07/06/2021

**Budawang School for Specific Purposes (SSD-8845345)  
Response to Submissions Report**

## **ATTACHMENT 1 – KEY ISSUES**

1 SITE PLAN  
1 : 250

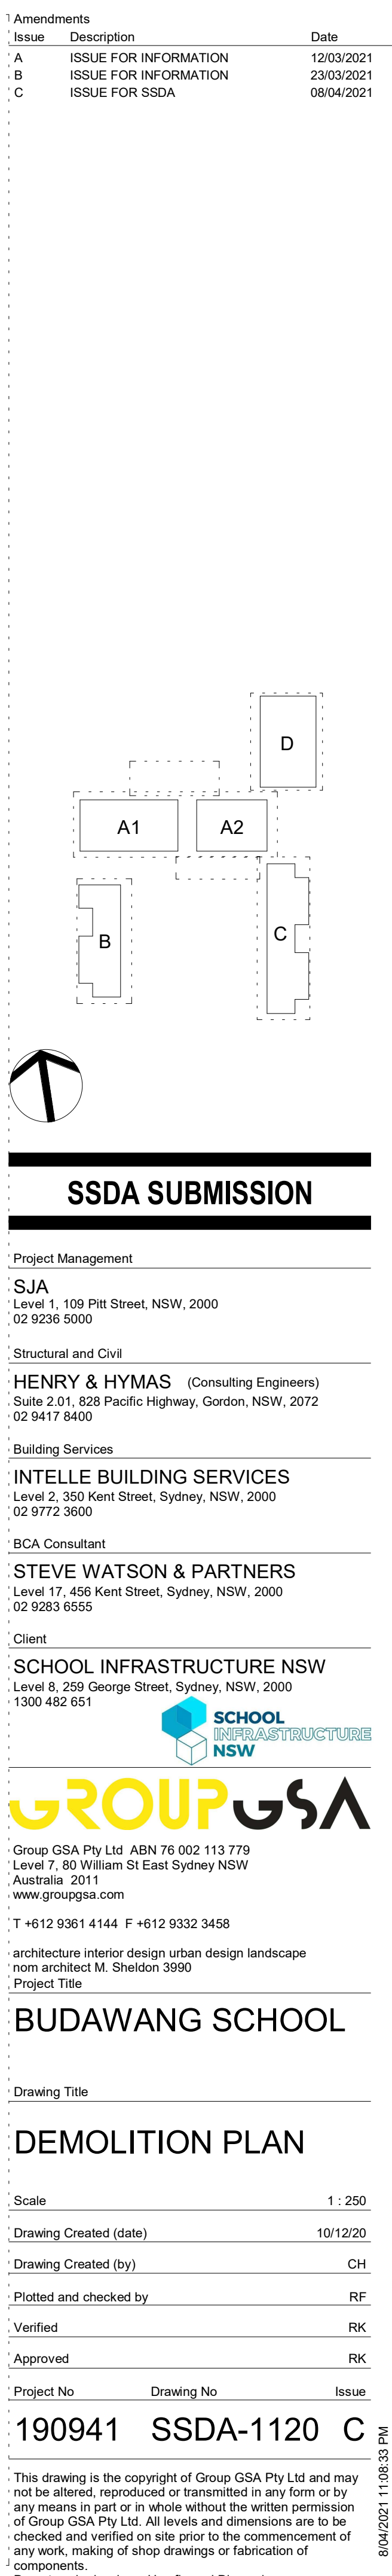
1. The proposed hydrotherapy facilities (Block D) are proposed for community use outside of the school's standard operating hours. It is unclear where parking would be provided for the public as there is no parking along Croobyar Road. It is also noted there is no pedestrian access along Croobyar Road. Further detail and discussion is required regarding public parking and access associated with the use of the hydrotherapy facilities.
2. Further justification is required for the proposed number of car parking spaces on site given that the school is proposed to operate with a higher teacher to student ratio than other schools.
3. Further detail is required regarding the indented bus bay along Croobyar Road and no location has been proposed on plan. Further details are required to ensure that potential vehicle / pedestrian safety issues are properly assessed.

7. Provide a response to the design recommendations identified by the Government Architect New South Wales in the correspondence dated 3 March 2021.
8. It is noted that there is a sewerage easement that dissects the construction site. Further clarification is required to understand if construction activities would impact on the sewerage pipe and any mitigation measures proposed.
